30 November 2020

Our Ref: 2020/532656
File No: R/2020/2/A
Your Ref: SSD-10421

New Request for Advice – Weigall Sports Complex, Sydney Grammar School – SSD-10421

# Planting Strategy

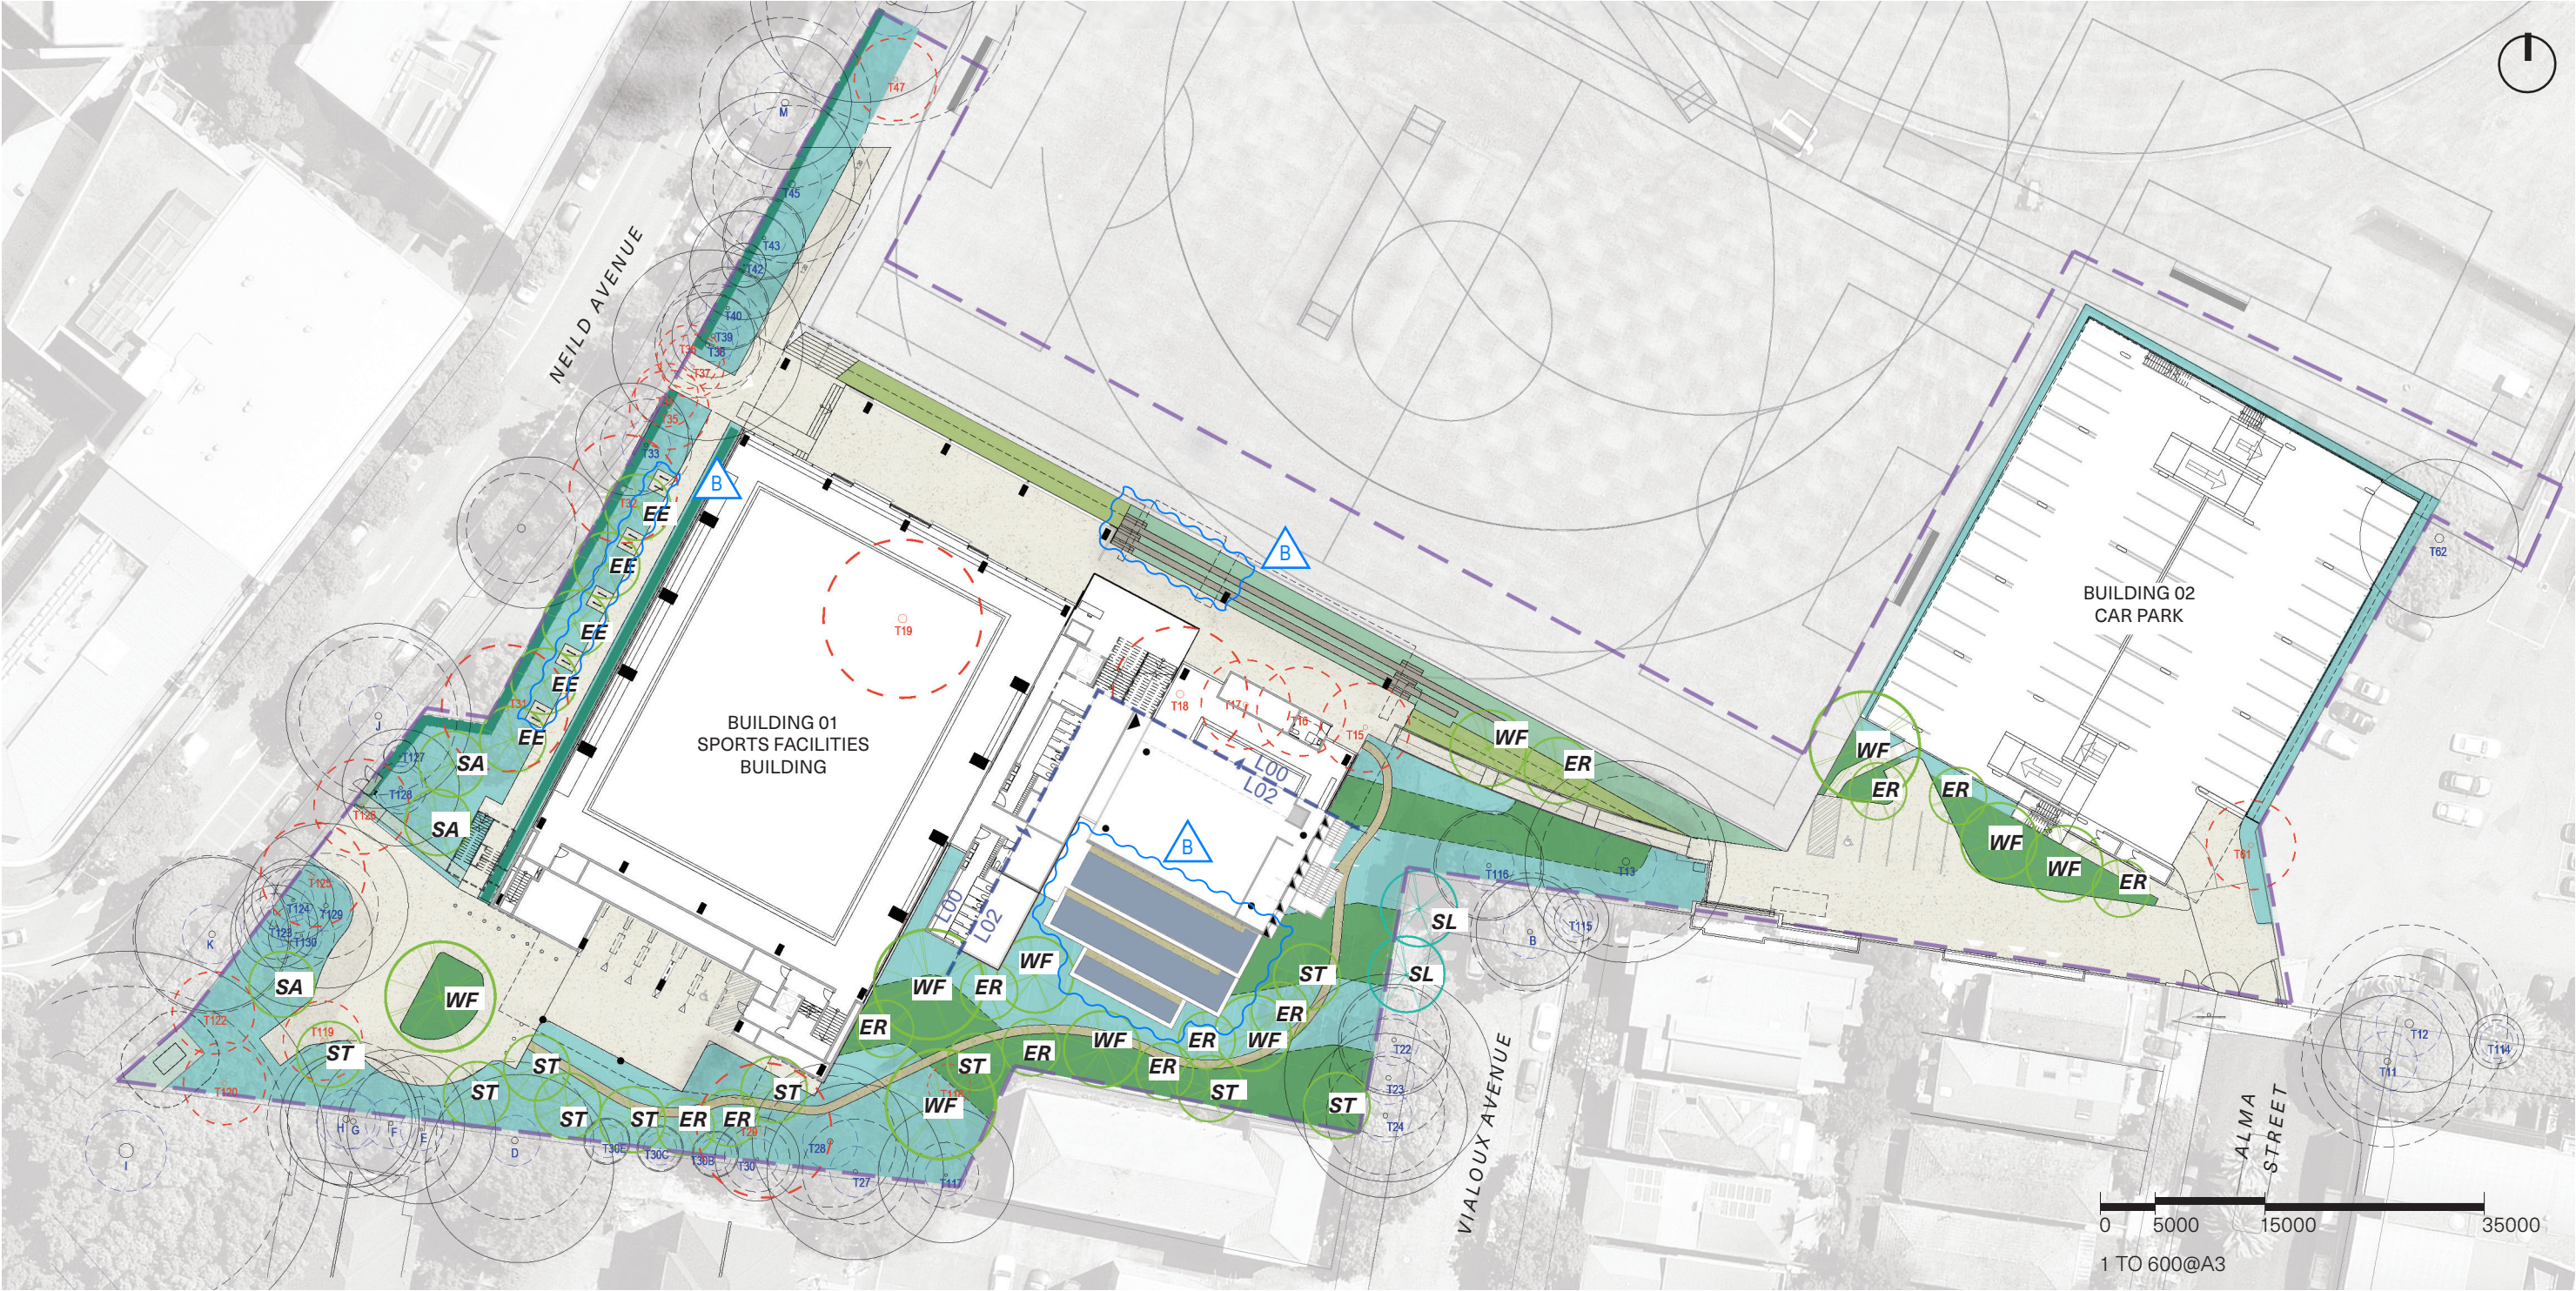
The City recommends replacement trees be supplied in accordance with Australian Standard 2303 (2015) Tree Stock for Landscape Use. It is noted however, that the following species identified may be difficult or not possible to source:

- *Pteridium esculentum*, suggest replacing with *Calochlaena dubia*
- *Darwinia fascicularis*,
- *Acacia terminalis*,
- *Melaleuca squamea*,
- *Dilwynia retorta*,
- *Epacris longifolia*

It is recommended that the proponent explore possibilities of ordering through specialist nurseries and if able to source, order replacement trees 6-12 months before the commencement of landscape works. This will ensure landscape diversity is not diminished due to lack of availability.

For tree removal and protection information refer to Arborist report

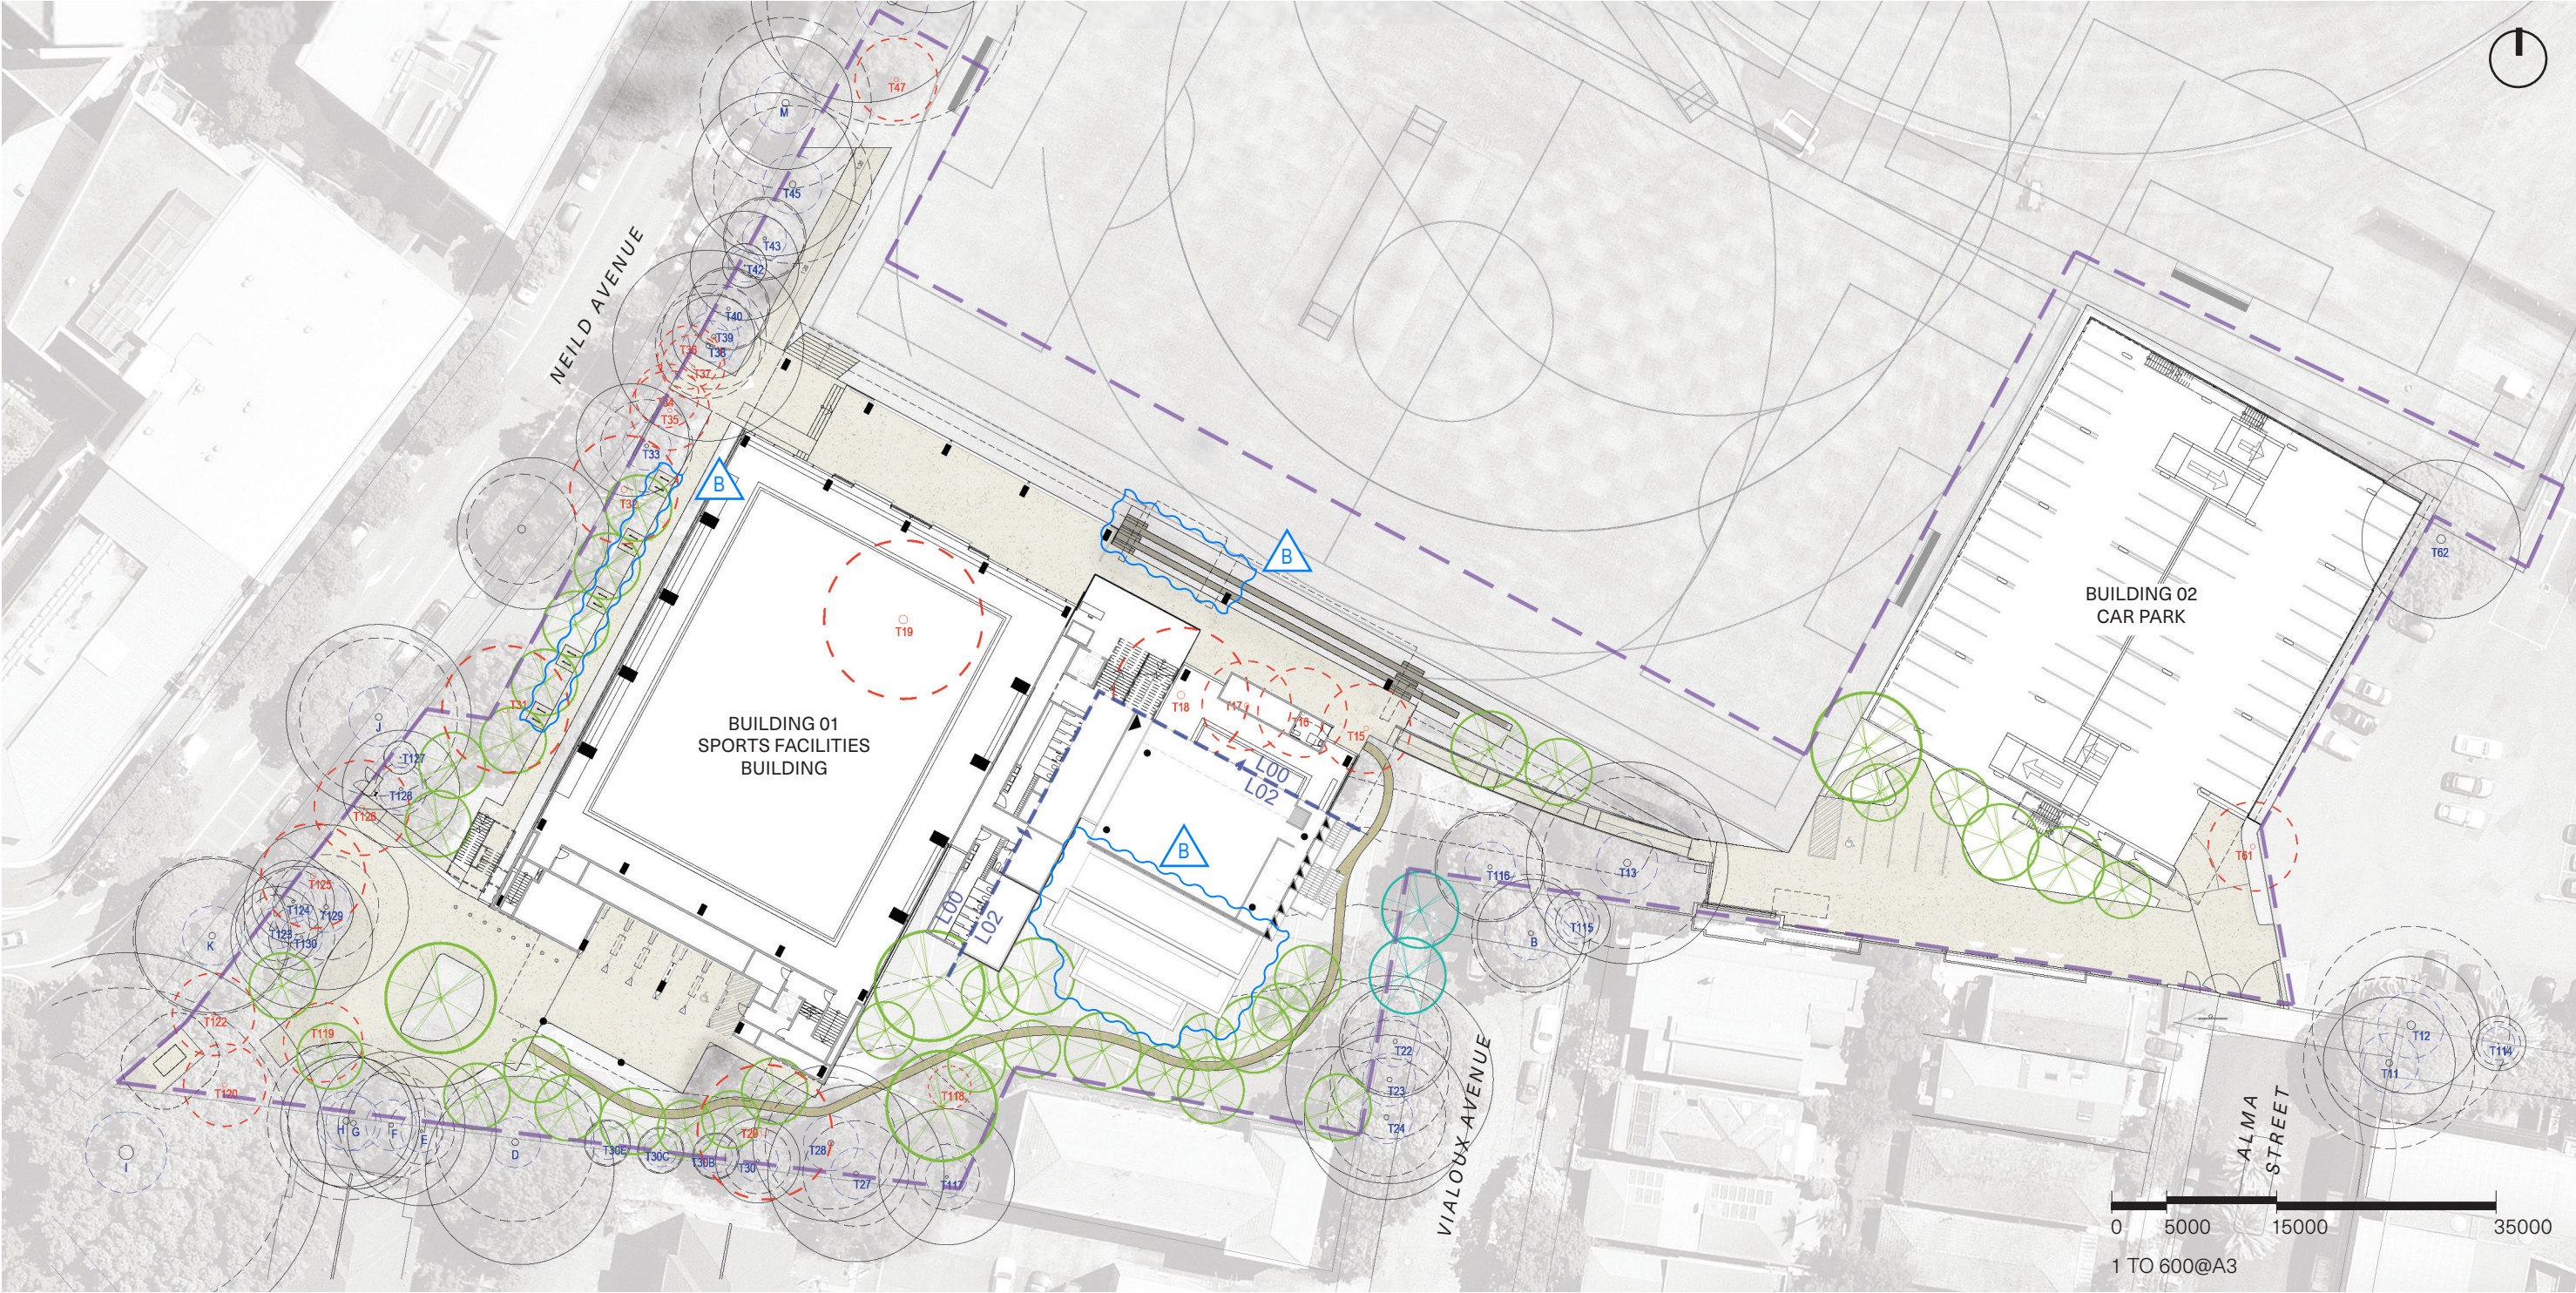
The submitted arborist report states that trees T32, T35, T36 and T37 are recommended for retention. However, they are proposed to be removed due to the building location / site access. These existing trees make a strong contribution to greening the streetscape and will help to screen this large building from Neild Avenue. The City recommends that these trees be retained and protected rather than replaced. Given the large land holding that can be built upon and accessed, it is not acceptable to be removing trees along the street boundary that can be retained. Alternative access through other available driveways would require fewer trees to be removed.
